Date: 01-Apr-2026
Our Ref: 2026/90407

**Application for a non-material amendment following a grant of planning permission,
Town and Country Planning Act 1990**

**Non material amendment to previous permission 2025/92104 for erection of two
storey side extension and extension to existing porch (within a Conservation Area)
50, Birkby Lodge Road, Birkby, Huddersfield, HD2 2BG
Application Number: 2026/90407**

Drawn No.
 101

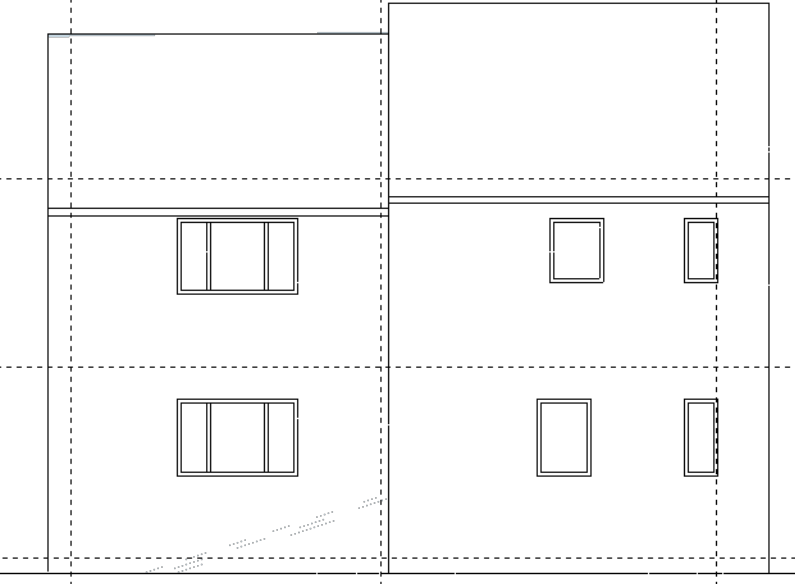
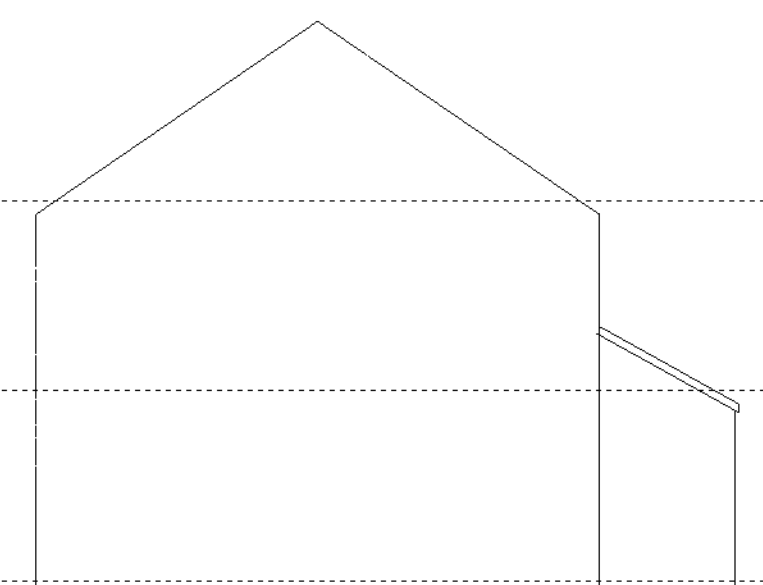
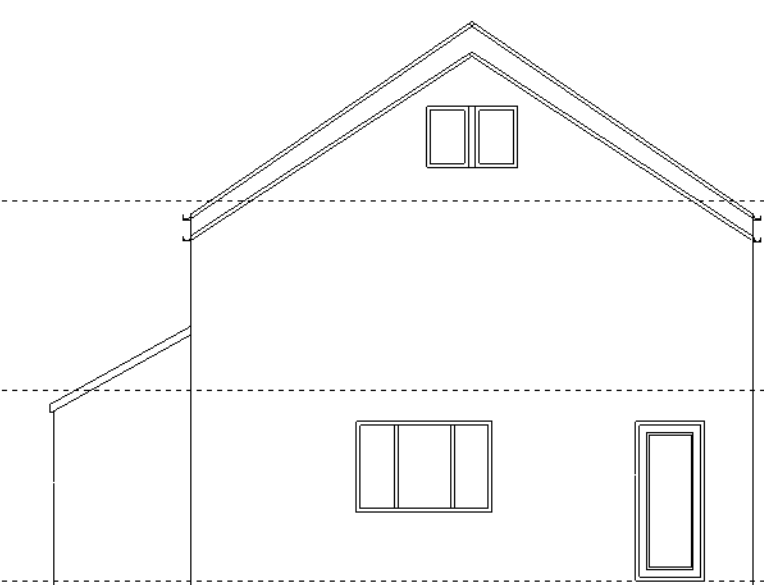
I am only able to consider non-material amendments to plans approved under a previous planning permission which are minor and do not materially change the appearance or character of the previously publicised scheme. The proposed alterations shown on drawing No's. 100 and 101 extend beyond this and hence I am unable to accept them. A new application will be required which will be subject to a further round of publicity and consultation.
